5 December 2019

File No: R/2018/33/A
Our Ref: 2019/595089

RE: Exhibition of Sydney Opera House – Amendments to the Lower Concourse Restaurant Area, Shade Covers, and Uses (SSD 9794)

Scale @ A1	1:50	Drawn by	Checked by
Scale @ A3	1:100	KR	GC
Project Issue Date	16/03/2015	Sheet Issue Date	26/06/19
Project No.	2466	Zone	LC
Discipline		Revision	D
Drawing No.	49HE001-3225

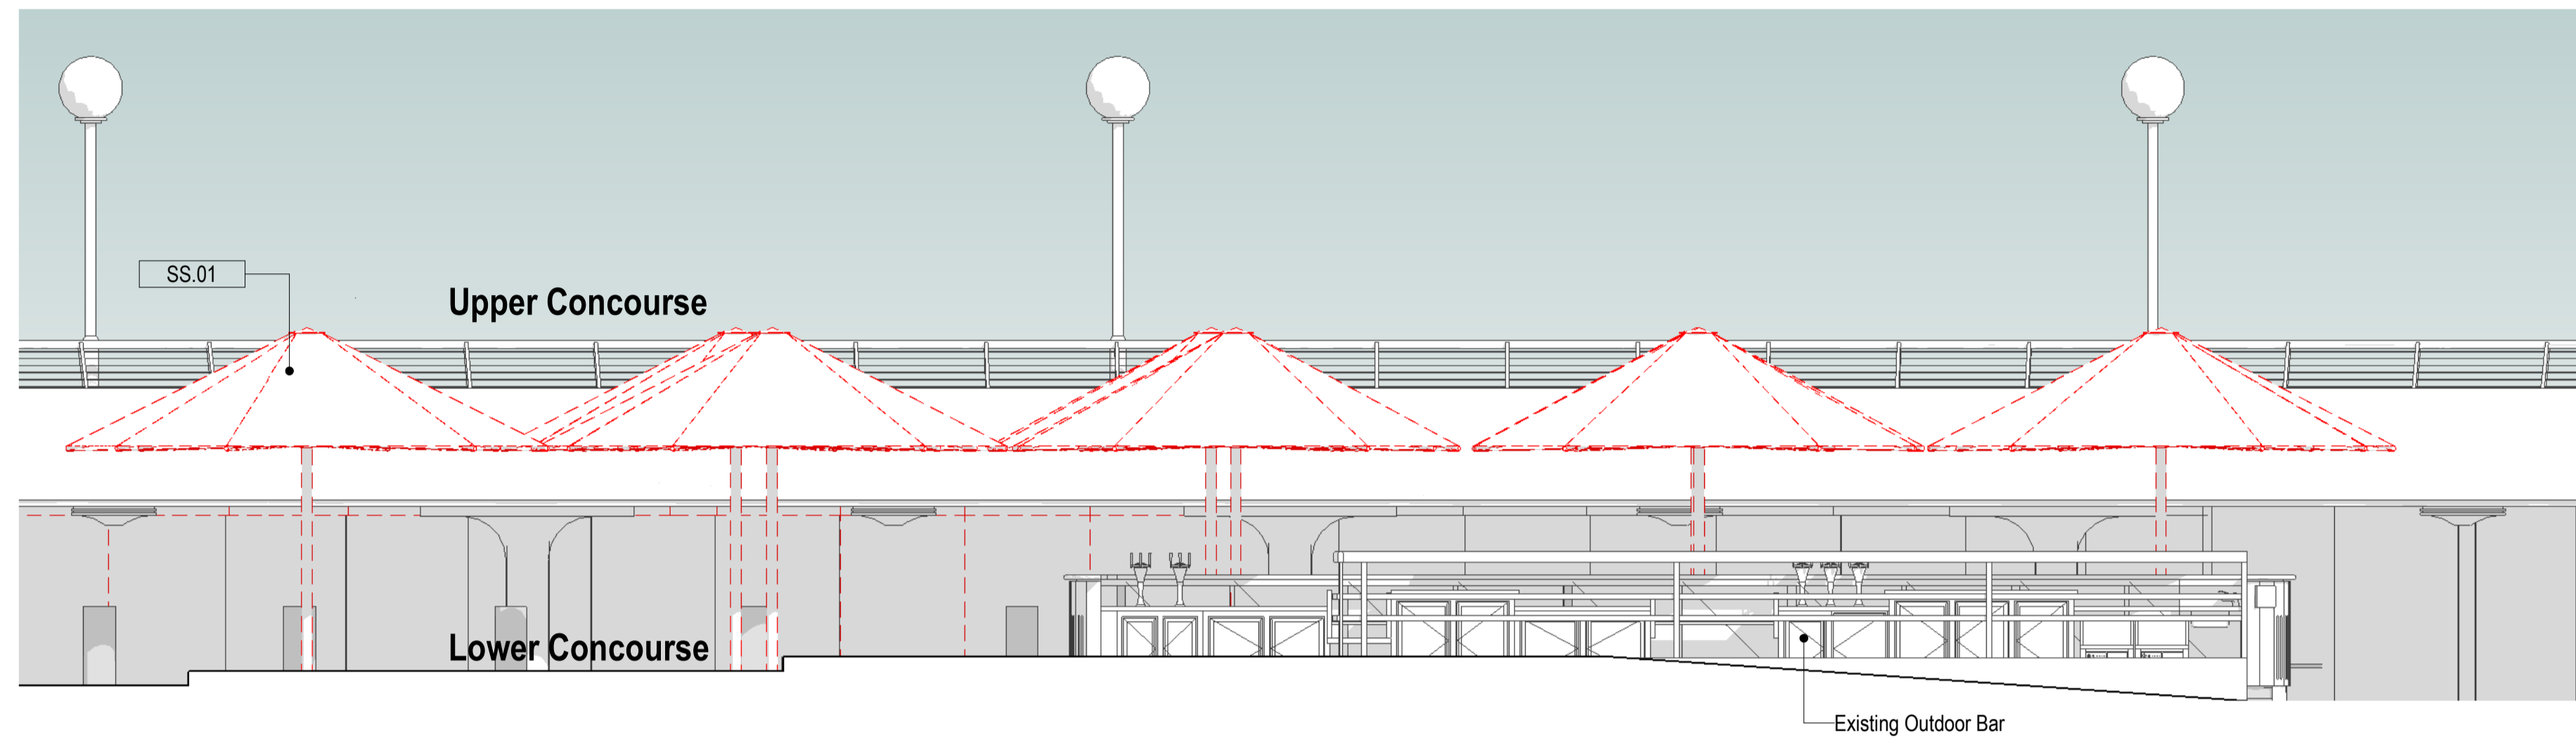
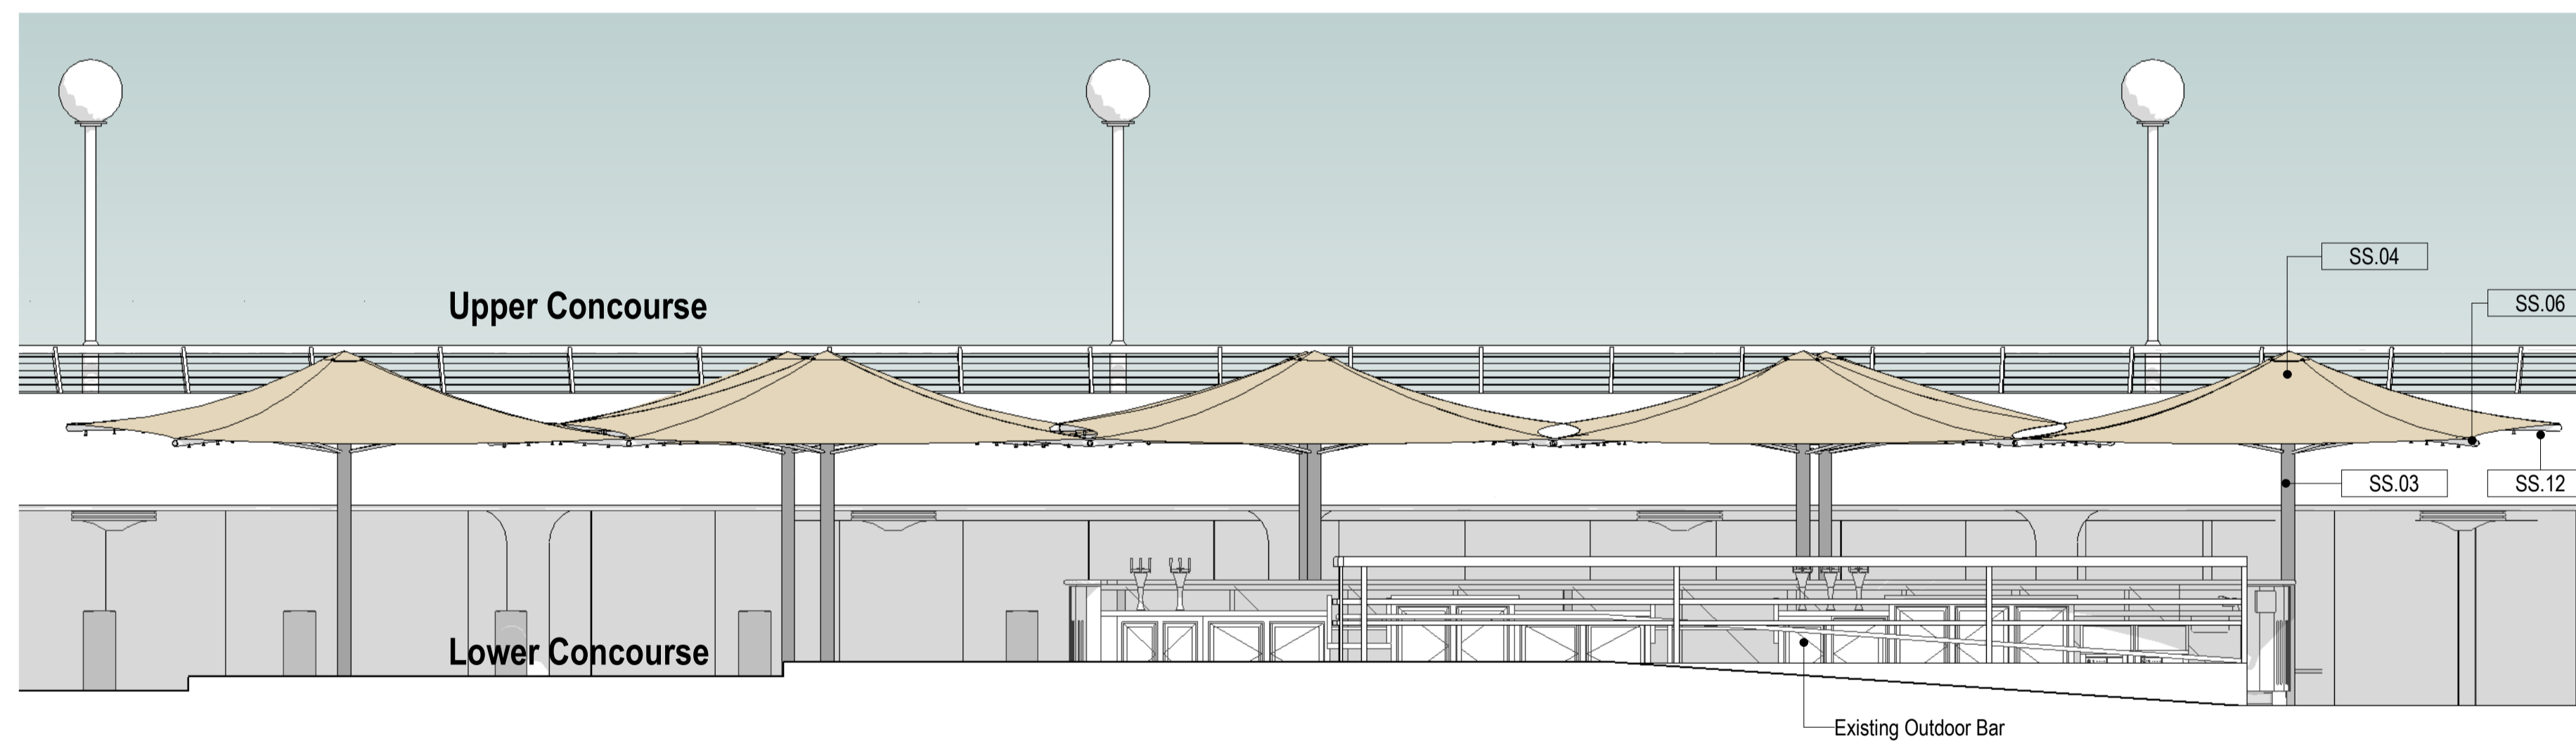
- c. Colour Selection: It is important that the proposed colour of the shade structures is similar to that of the exposed aggregate concrete panels to reduce the visual impact. There is a note on the drawings (49HE001-3225 D and 49 HE001-3230 C) related to the colour of the tensile fabric. – 'SS.04 Tensile fabric equal to serge Ferrari Soltis, colour closest approved match to Dulux Coconut Husk, to be designed and installed to approved details.'

If the colour has not already been approved by the consent authority (as opposed to the Client) a coloured fabric sample would confirm the colour of the shade structures.
